**ANGEL PLACE
LEVEL 8, 123 PITT STREET
SYDNEY NSW 2000**

7 March 2023

HERITAGE RESPONSE TO RFI | DEPARTMENT OF LANDS BUILDING, 23-33 BRIDGE STREET, SYDNEY (SSD 7484 – MOD 18)

3. DEPARTMENT OF PLANNING AND ENVIRONMENT SUBMISSION (REF: SANDSTONE PRECINCT – LANDS BUILDING CEILINGS (SSD-7484-MOD18), 10 FEBRUARY 2023

Figure 1: Ground floor plan denoting G.01, 04 and 07

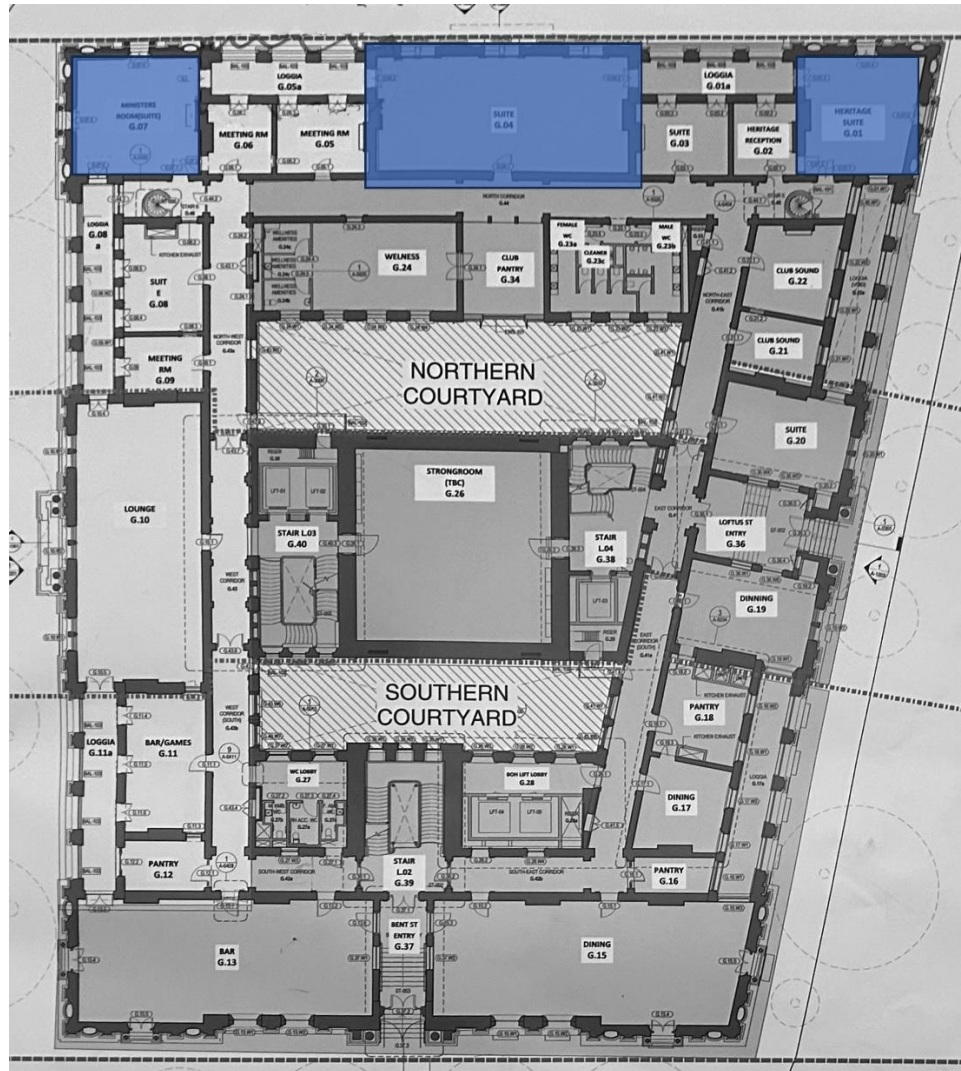
Ref.	Matter raised	Response
		Urbis also understands that, as part of the RTS response, a point cloud survey of the ceilings and cornices will be undertaken.
	<i>Two sample rooms, one containing intact timber lath & plaster ceiling and the other containing metal mesh lath & plaster ceiling (e.g. G07 which contains original painting scheme), including their cornices, should be retained to demonstrate the original construction details.</i>	Refer to discussion at point 1.2, above.
	<i>All new ceilings are to be finished with a coating and finish that is consistent with the original set plaster finish.</i>	Refer to discussion at point 1.1, above.
	<i>Further tests of salvaging more cornices (than the proposed) and options to retain the wall cornices in-situ are to be explored.</i>	Refer to discussion at point 2.1, above.
	<i>The replicated cornices are to use the same material and finish as the existing. The samples/prototypes of all types of new cornices are to be reviewed by Heritage NSW and City of Sydney prior to their manufacturing.</i>	All new cornices will match or interpret existing original cornices with respect to design and finish. New cornices will, however, be manufactured using contemporary materials and techniques due to fire rating requirements. We note that contemporary techniques were used by the Traditional Restoration Company to replicate cornices at the neighbouring Department of Education building, to highly satisfactory results.
